## ABLE MARINE ENERGY PARK (TR030001)

Written proof of oral evidence from the Specific Issue hearings held on 12 and 13 November 2012

1. The Development & Operation of the Intertidal Habitat Site &
2. The Development of the Wet Grassland & Roosting Site

Figure 36.1 Existing drainage pattern at Cherry Cobb Sands

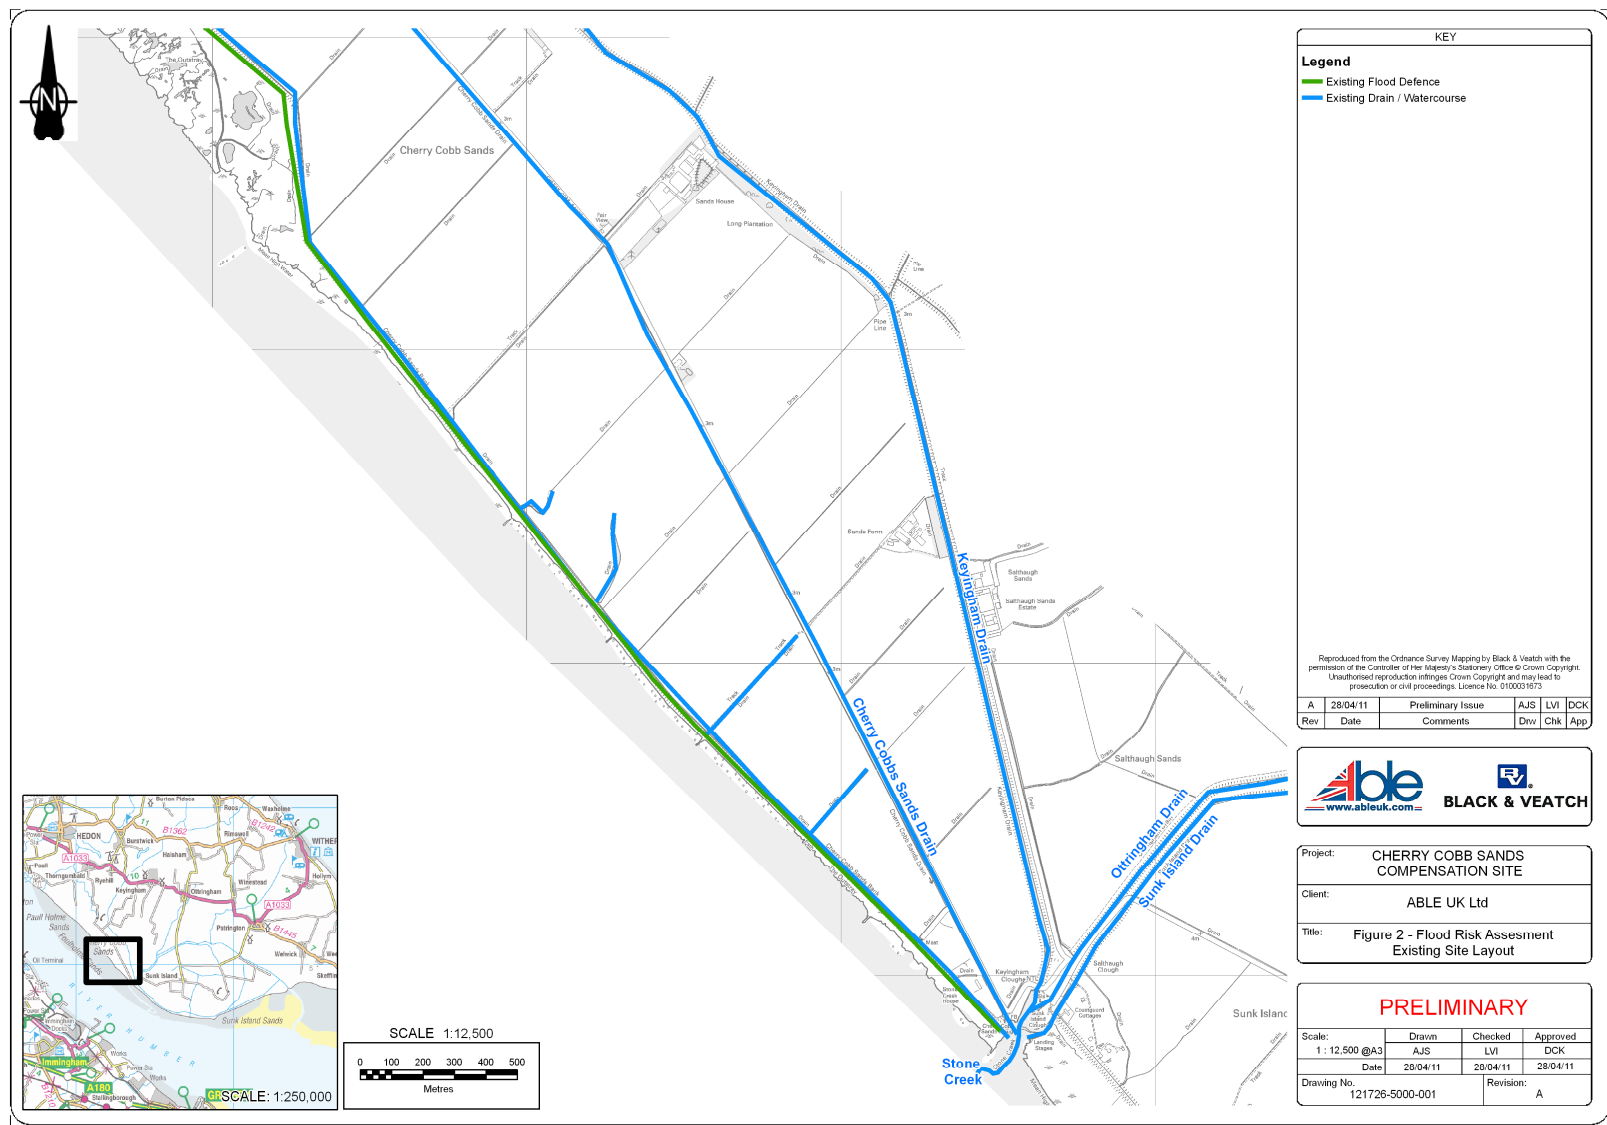
1. **the flow from Stone Creek into the Humber will be reduced** by the above developments. This will lead to silting up of the Creek, so that the outflows from the Sunk Island Drain will be adversely affected.

2. **the managers of the Wet Grassland & Roosting Site will interfere with the natural working of the hinged timber pointing doors**, as they wish the Keyingham Drain (KD) to fill up to make more water available to the wet grassland. The pointing doors are designed to open and close as the water pressure changes with the tides. If the doors are interfered with so that they do not open & close with each tide, Stone Creek (which receives this water) will not be scoured out, & thus it will silt up. If Stone Creek silts up, the Sunk Island Drain will not freely empty into the Humber as the water requires a free flow through a scoured out channel.

3. **the Environment Agency will interfere with the natural working of the hinged timber pointing doors** because they are more interested in wildlife and associated habitats than land drainage. By controlling the opening & closing of the pointing doors the EA are able to create a habitat that they consider to be more advantageous to wildlife. But if the EA cause the doors not to open & close with each tide, Stone Creek (which receives this water) will not be scoured out, & thus it will silt up, & so reduce the efficiency of the Sunk Island Drain.

4. **the Environment Agency (EA) does not understand that the main function of the Keyingham Drain is land drainage**; the EA said it was flood defence, which is incorrect. The KD was built to drain a large area of Holderness. The hinged timber pointing doors on the KD at Stone Creek were built so that water is drawn out of the Drain at low tide. The doors' primary function is not to act as a tidal barrier, as insinuated by the EA, nor to drain heavy rainfall from inland. Flood defence is a secondary function. Regular, routine internal land drainage is the primary function.

5. **the salinity of the Keyingham Drain will only be reduced if the EA interfere with the opening & closing of the doors**. Non-saline water is required for the wet grassland, but the water at the Stone Creek end of KD will always be mixed with salty water if the doors are allowed to act as intended.
